Application No: EP/11/22/HH
Site Address: 24 Normandy Lane East Preston BN16 1LY
Description of works: Erection of single storey rear extension and external alterations following the demolition of existing rear conservatory/lean to.

Thank you for your internet representation made on 10th March 2022 which has been recorded as an objection with the comments as follows:

MR & MRS McGONIGLE	24 NORMANDY LANE EAST PRESTON WEST SUSSEX BN16 1LY	PROPOSED SIDE ELEVATION 'B'	P.D. ELKINS DRAWING SERVICES LIMITED 140 Kingston Road Ewell Surrey KT17 2ES Tel. 020 8873 3138 email. elkinsdraw@aol.com
--------------------	--	--------------------------------	--

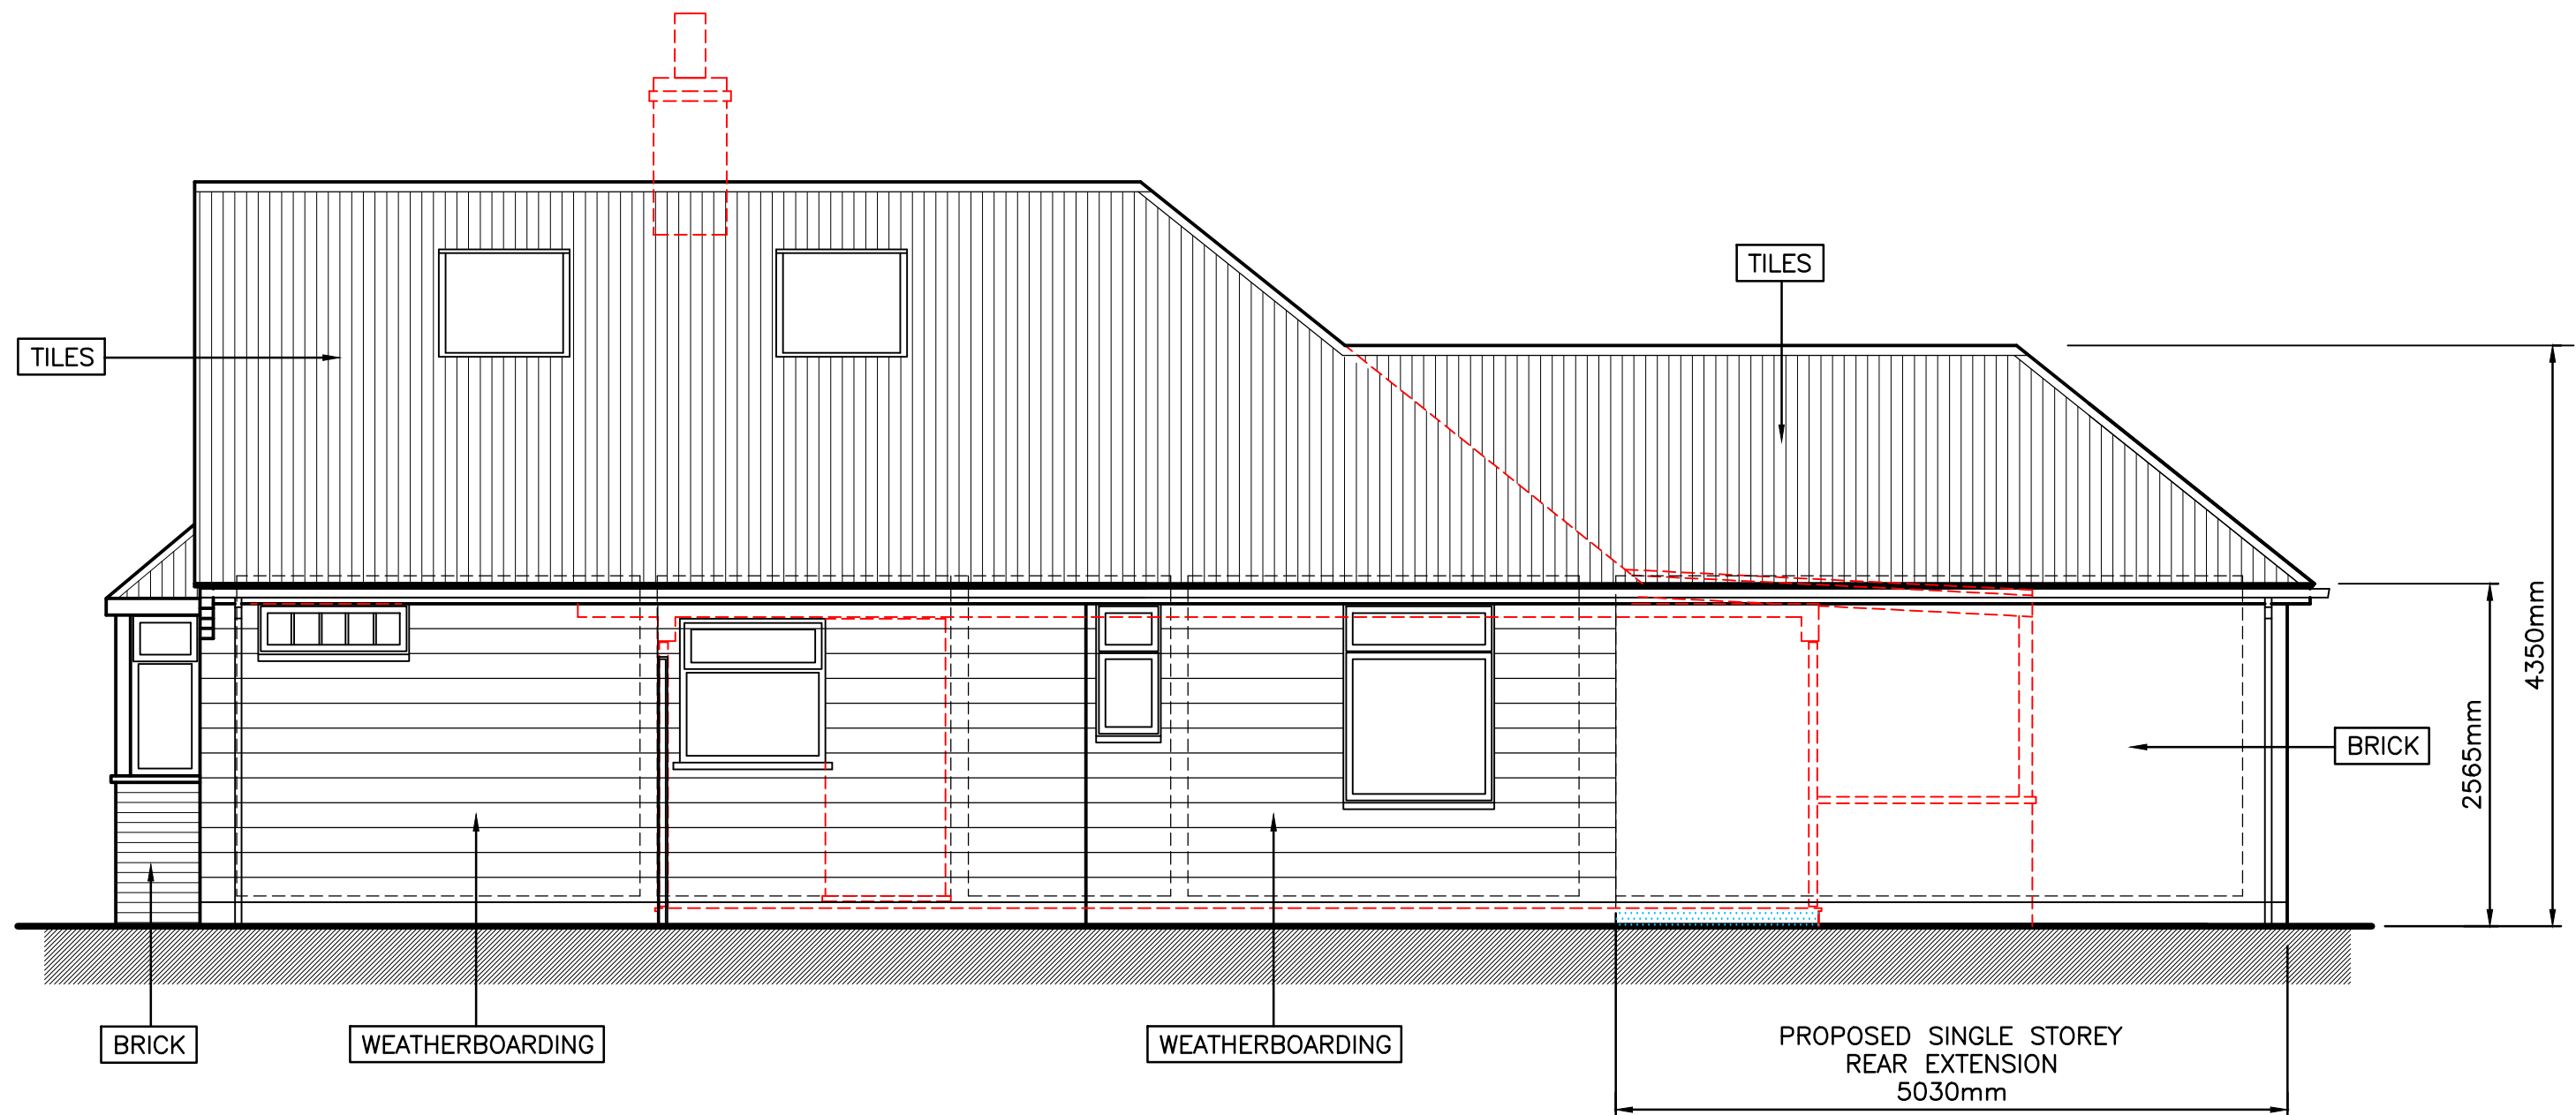
I write on behalf of the East Preston and Kingston Preservation Society. We have some concerns about this application. The starkly vertical side gable proposed for the north elevation would not be unobtrusive viewed from the street and might be overbearing on the neighbouring property, contravening Policies D DM1 and D DM4 of the Arun Local Plan. The proposed materials, especially the replacement of an original brickwork gable feature with Tudor-style timbering out of character with the rest of this road, would disregard Section M of the Arun Design Guide. For these reasons the Society requests that this application be refused.
